Department of Planning, Housing and Infrastructure

24 October 2025

Re: Objection to SSD-82599709 – Proposed 51 storey mixed use building containing ancillary retail premises, hotel and 296 residential apartments at 153–157 Walker Street, North Sydney

# Hotel Floors Level 01

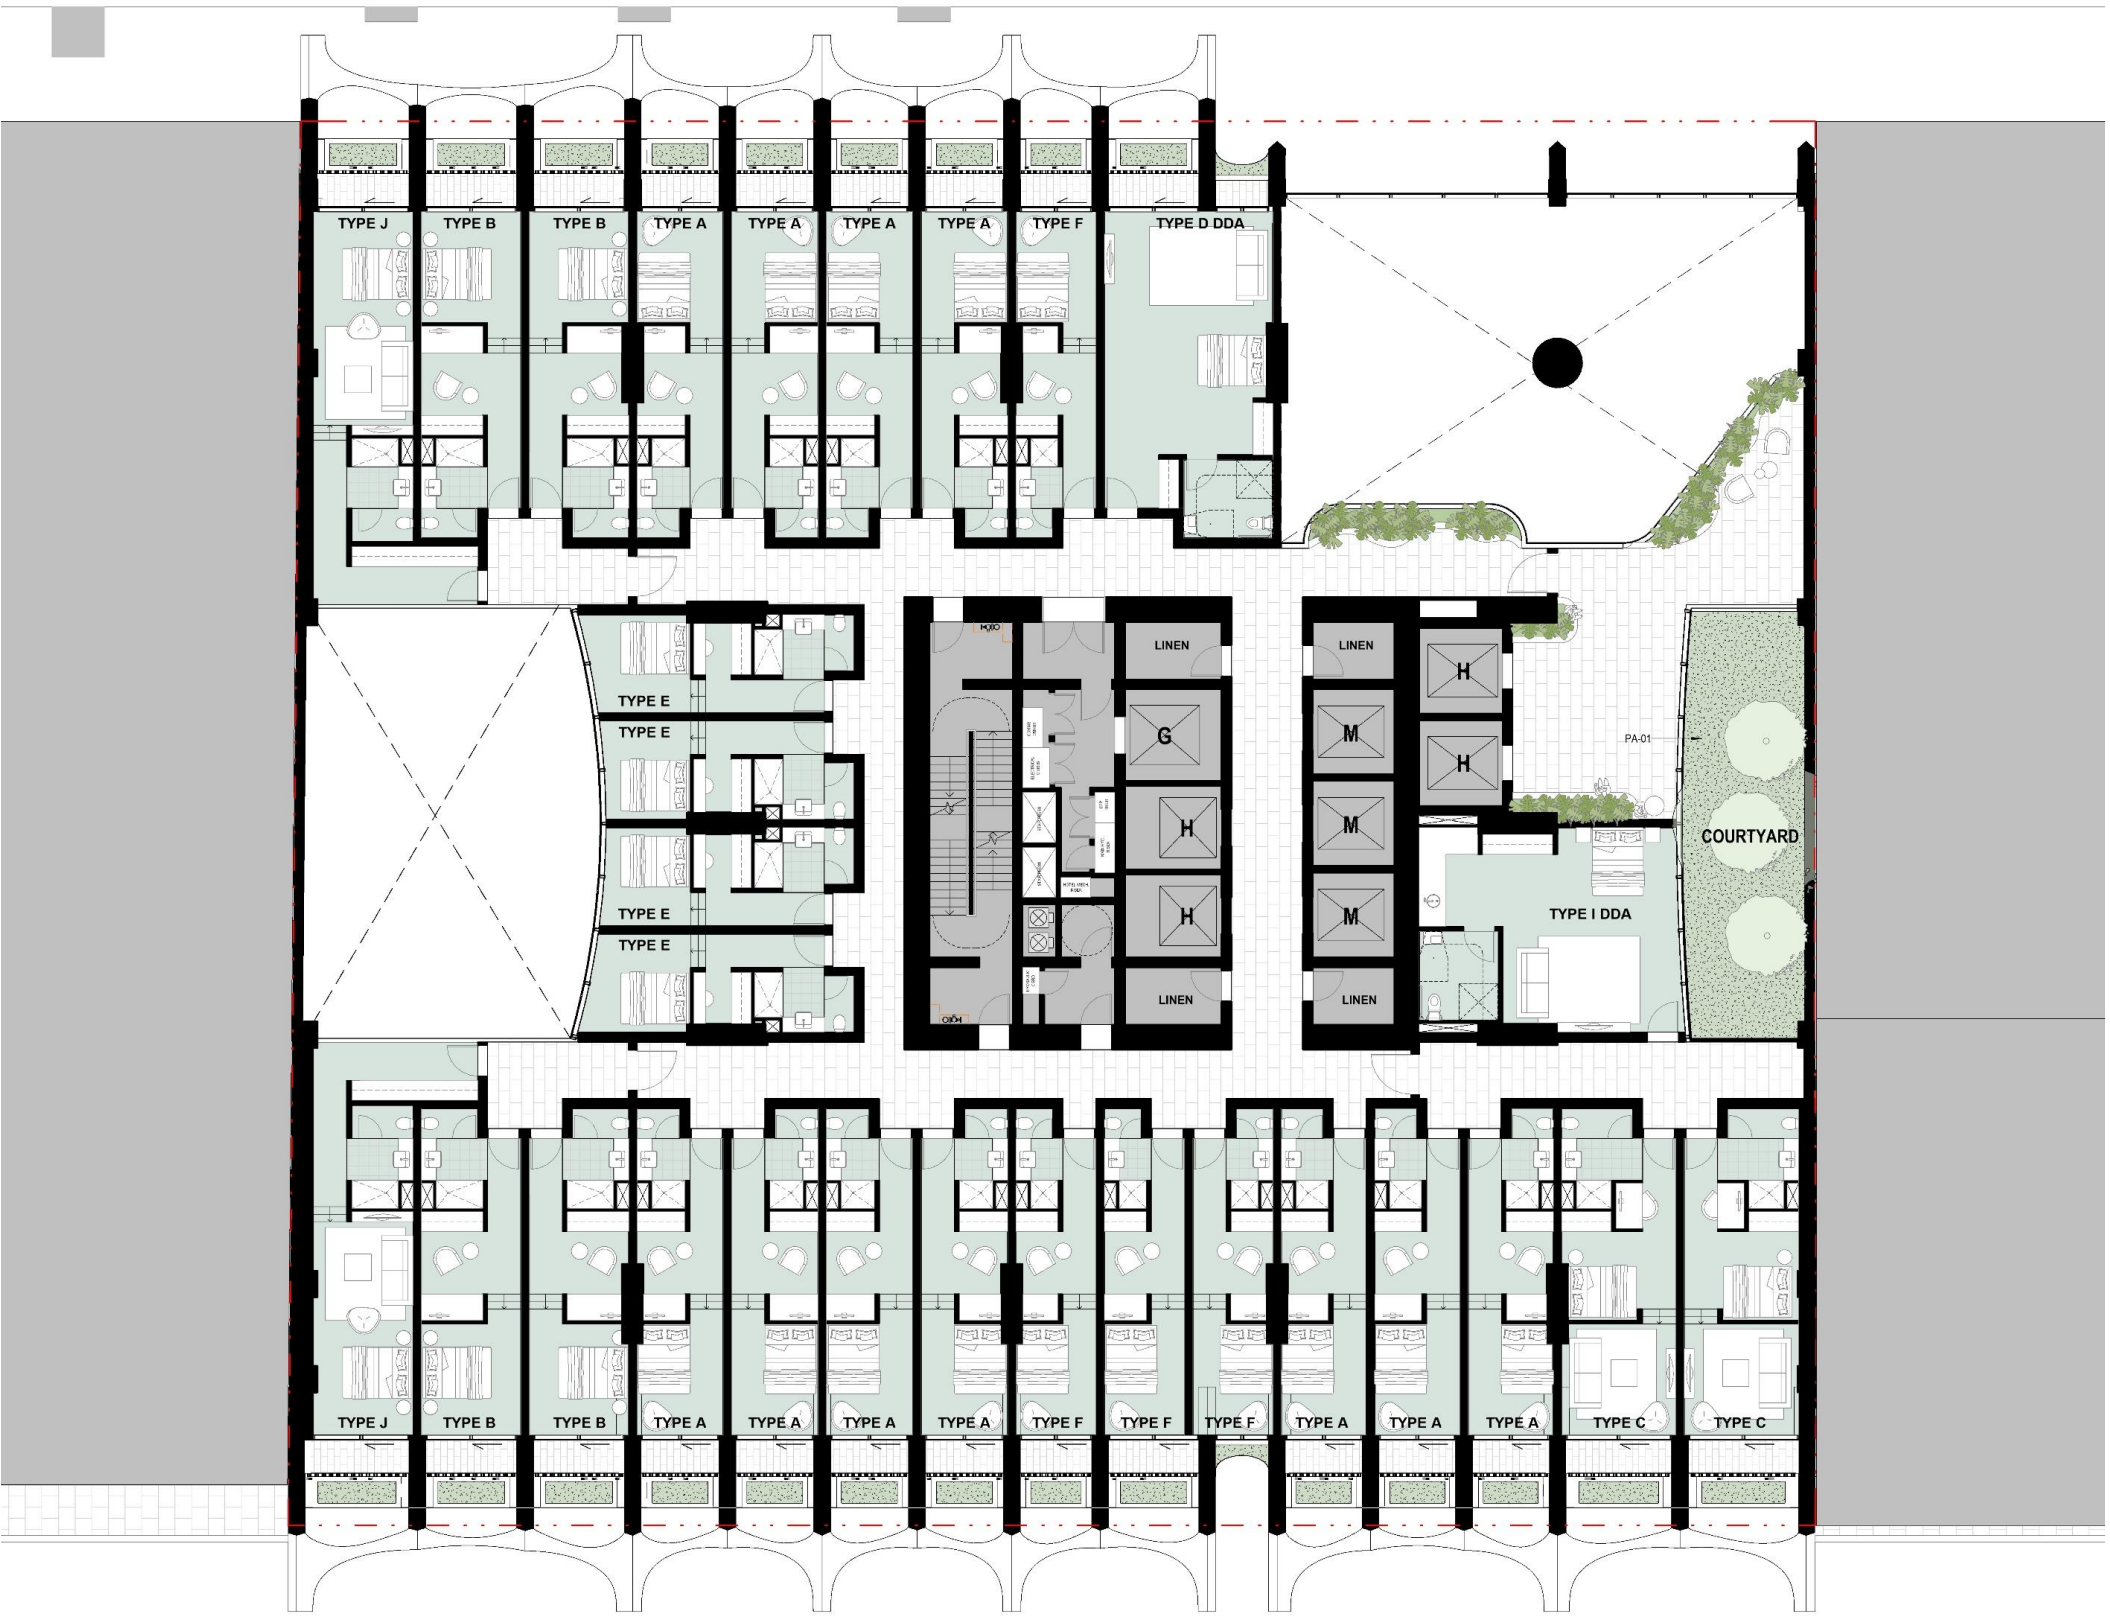
The current design proposes significant encroachment onto the public street frontages of Walker Street and Little Walker Street, with a portion of the privacy walls between the hotel rooms and the curved awnings proposed to be constructed outside of the site boundary.

## South Facing Apartments

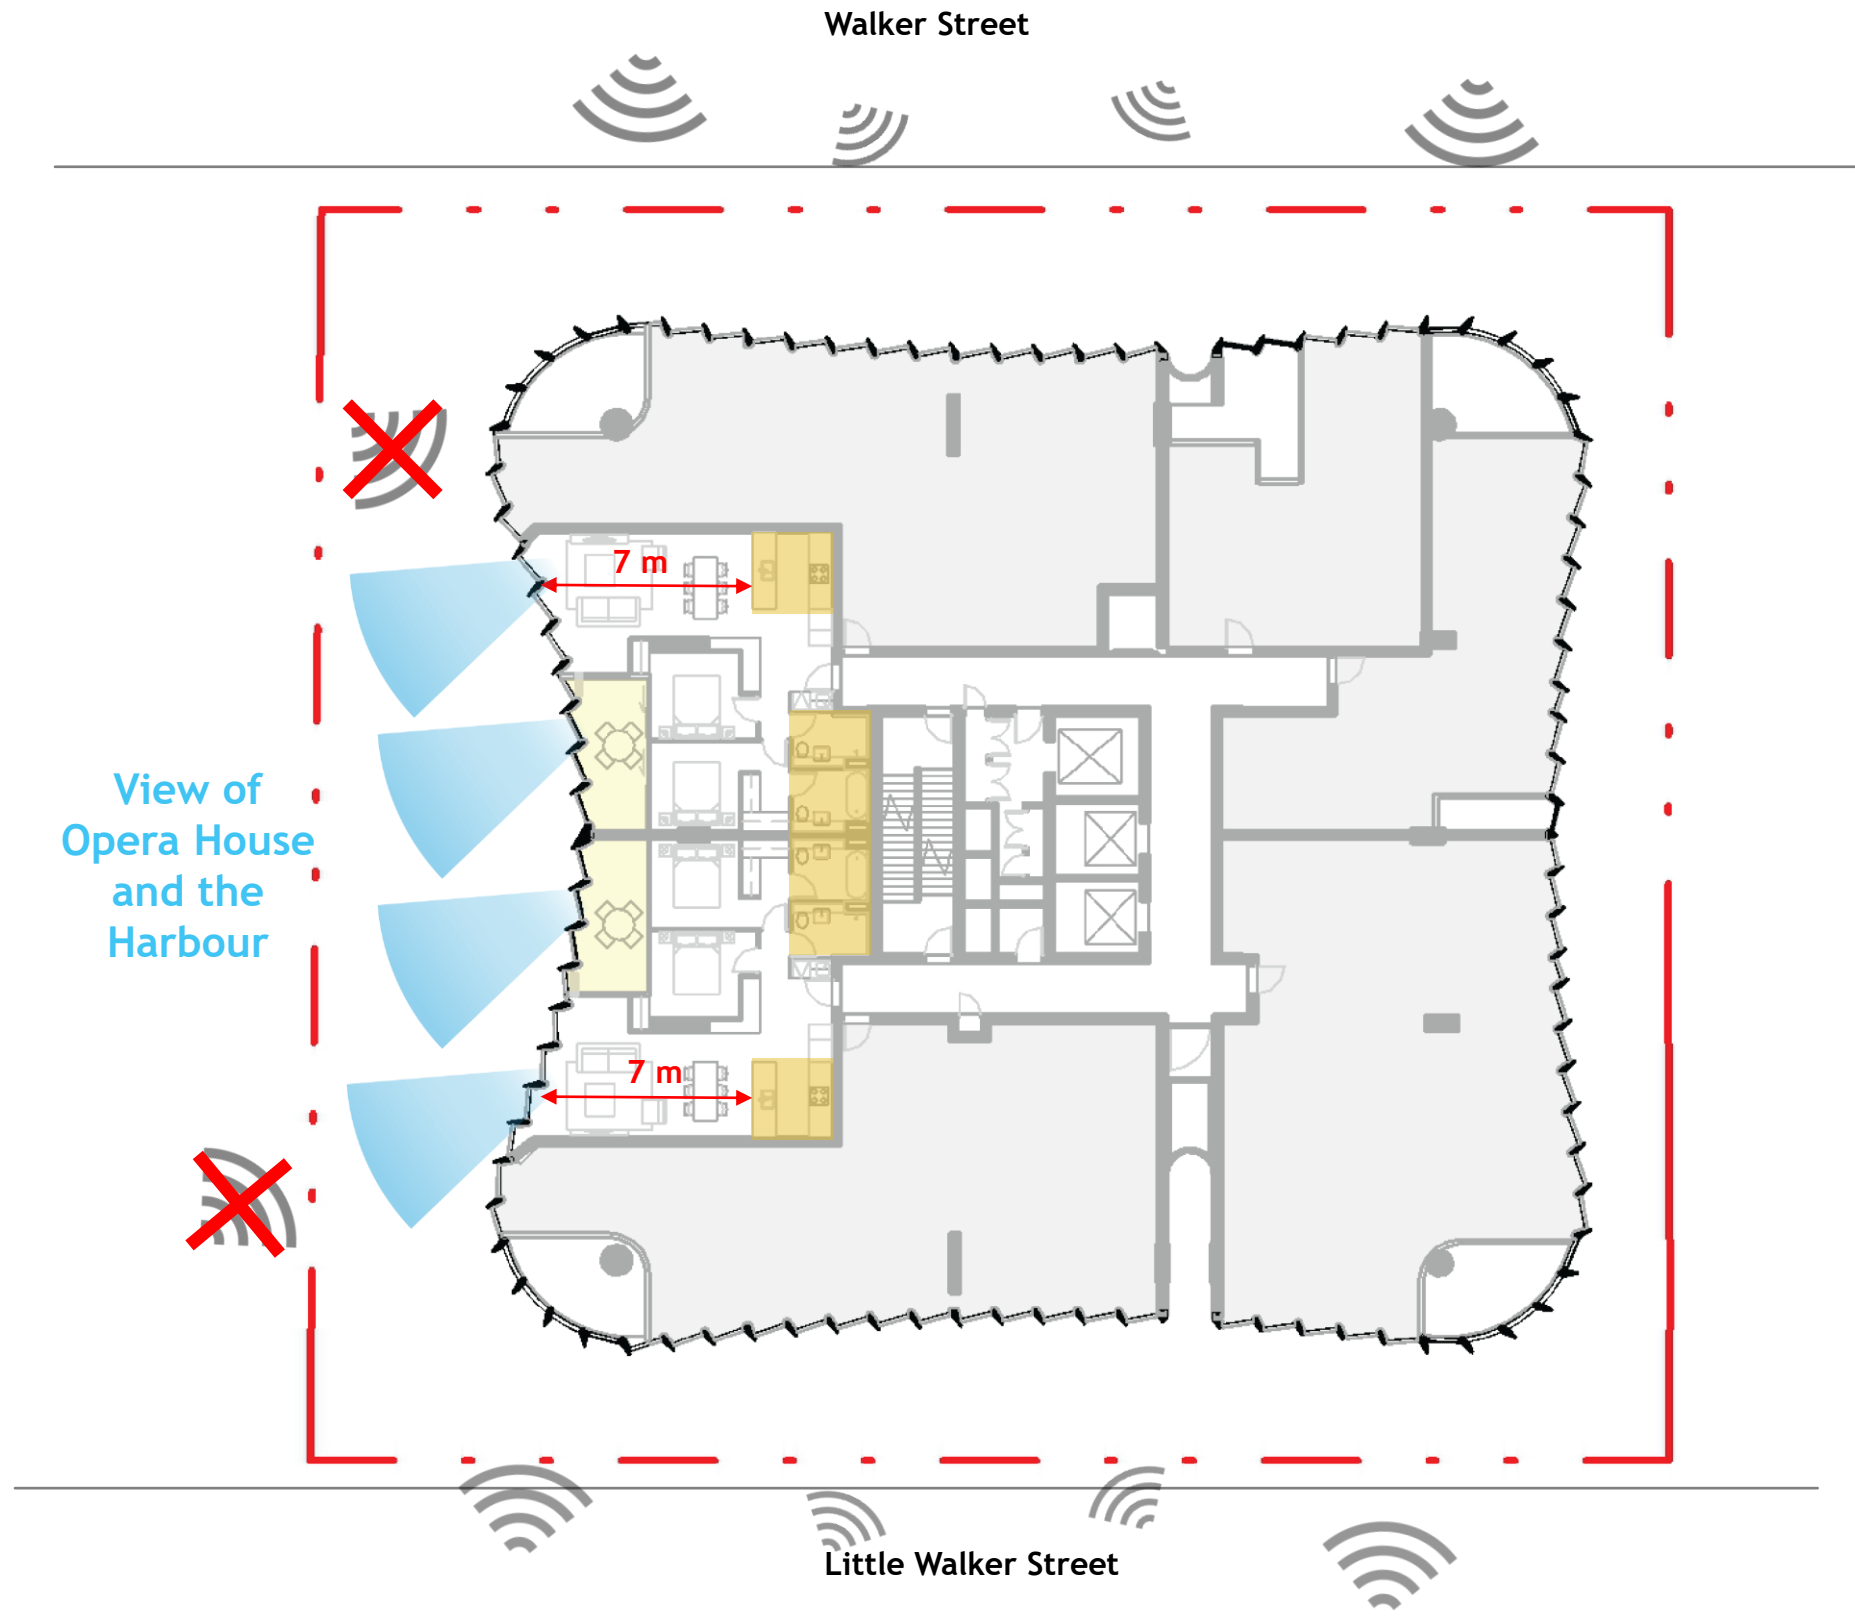
In accordance with the Apartment Design Guide, the number of apartments receiving no solar access, should not exceed 15% and the proposal does not meet this minimum standard. The development proposes to orient approx. 20% of units to the south and these units do not achieve the minimum solar access required.

## Building Separation - South View

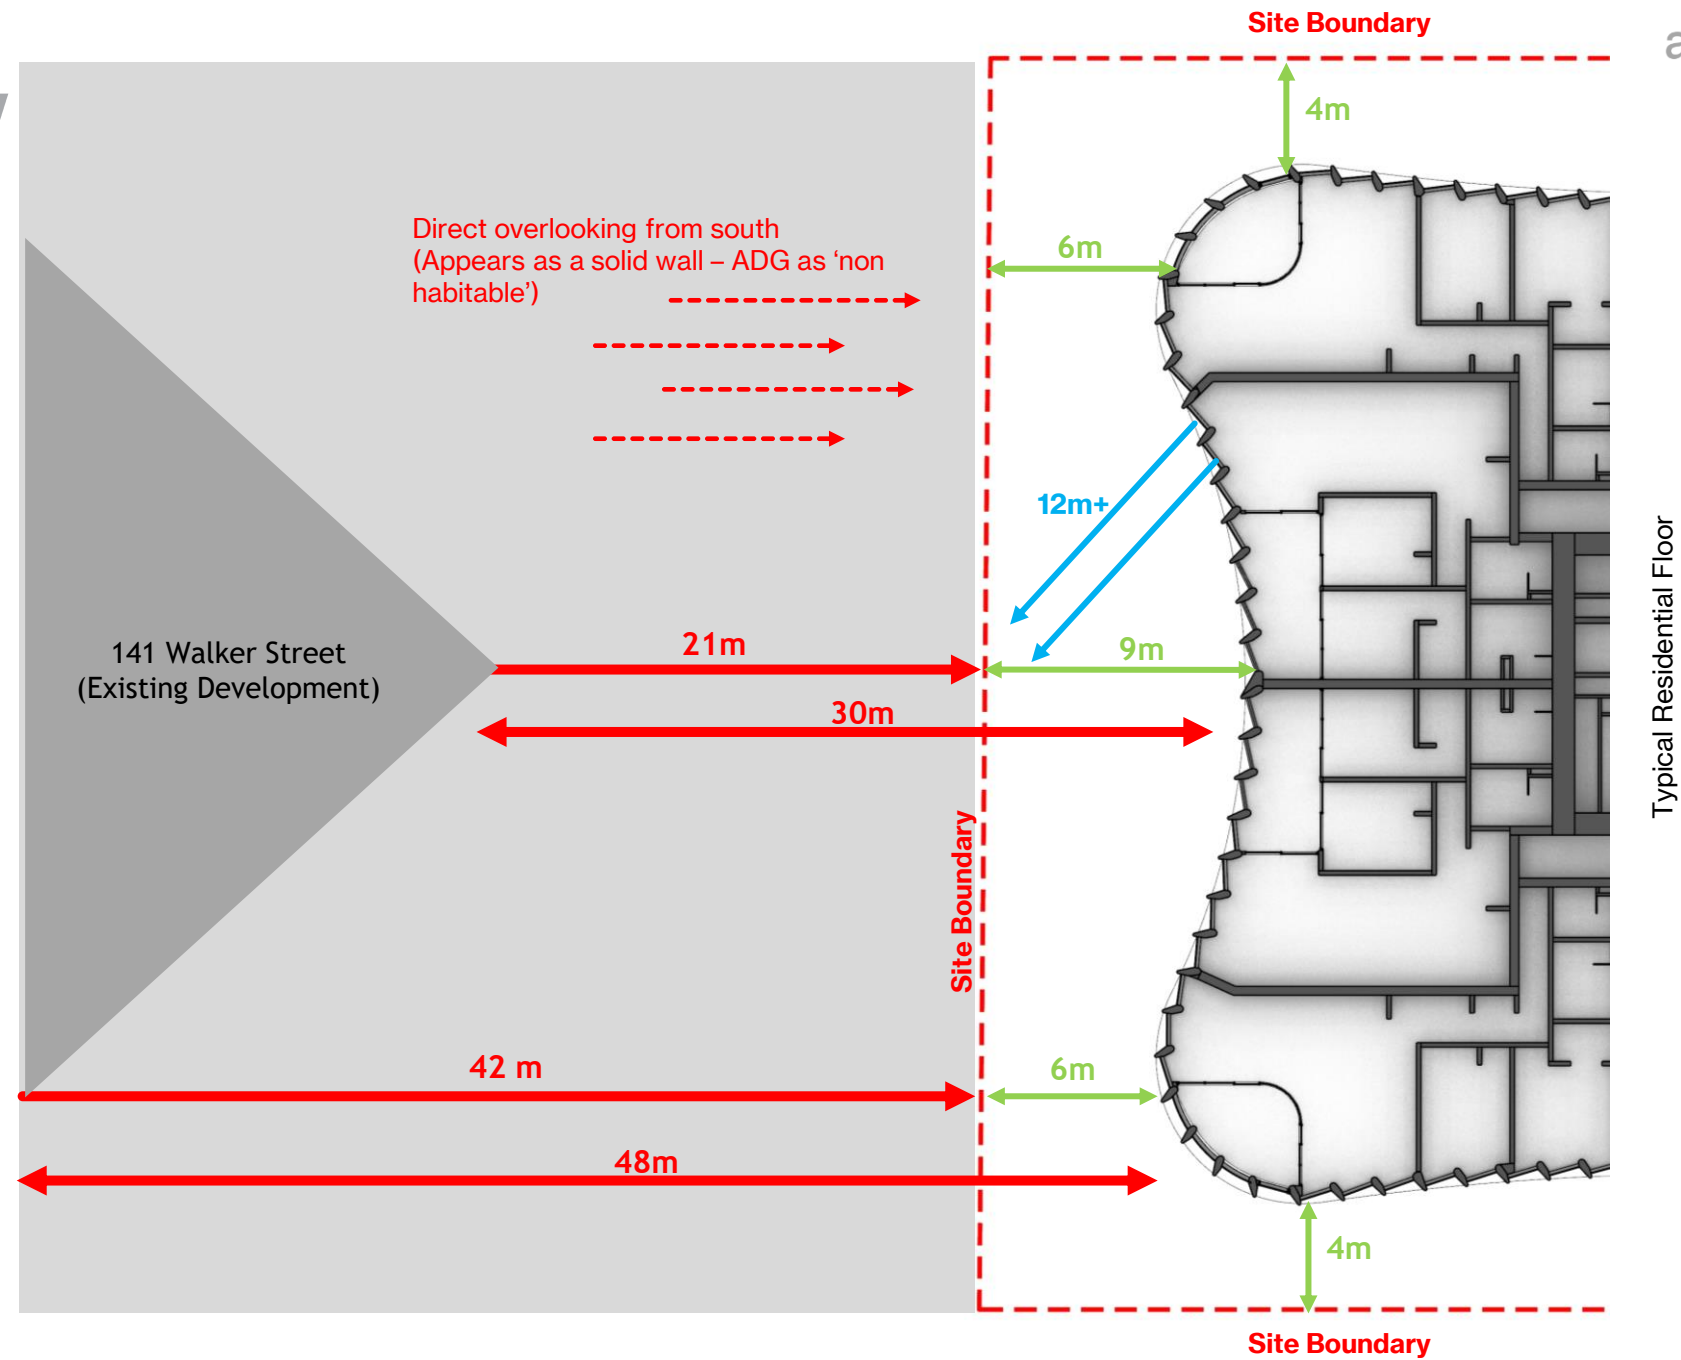
The ADG requires a minimum 12 metre setback on each site between habitable rooms, achieving a combined separation of 24 metres between adjoining buildings. The development proposes setbacks of just 3 metres (north) and 6 metres (south), significantly less than the minimum required, as illustrated below.

The proposed setbacks are not adequate and demonstrate the site is not large enough to accommodate a building of this scale.

The proposal also assumes that our client's site will be retained in its current form or be redeveloped as commercial, which has a far lesser level of privacy and setbacks required. However, a reasonable assumption is that 141 Walker Street may development in the same manner as the 153-157 Walker Street. If this is the case, it is imperative that the maximum setbacks are provided, so that the development potential of 141 Walker Street is not compromised. We strongly oppose the proposed setbacks to 141 Walker Street, based on the substantial impacts the proximity has on future development potential with regard to residential amenity, privacy, solar access and general bulk and scale. We note that this should also be considered for 161-165 Walker Street, as they may also wish to develop in the future.

### 161-165 Walker Street Commercial

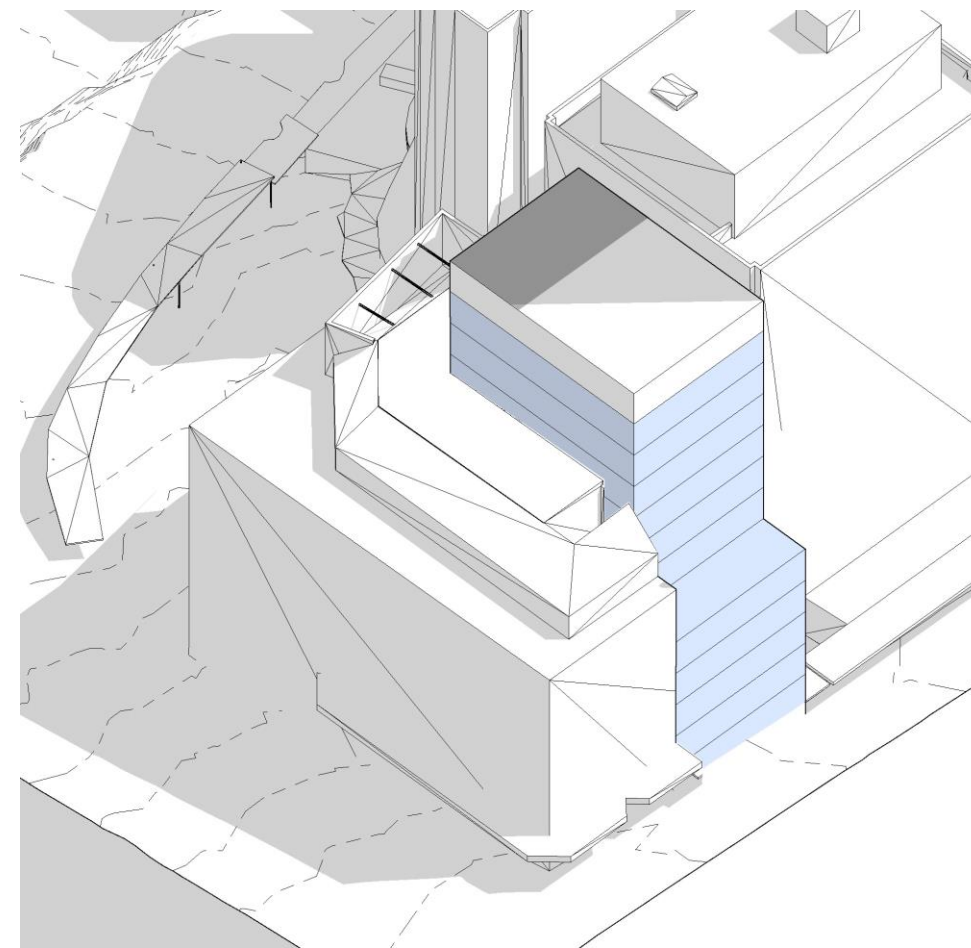
If the development were to proceed in its current form, the future development potential of 141, 161 and 165 Walker Street would be severely limited, in particular No. 161 and 165 will become isolated, as they are bound by Berry Street to the north (illustrated below).

It is considered the development would be better suited to a consolidated site, incorporating the lots to the north, as this would allow for improved site access, increased solar access and a sufficient area to provide generous and compliant building setbacks.
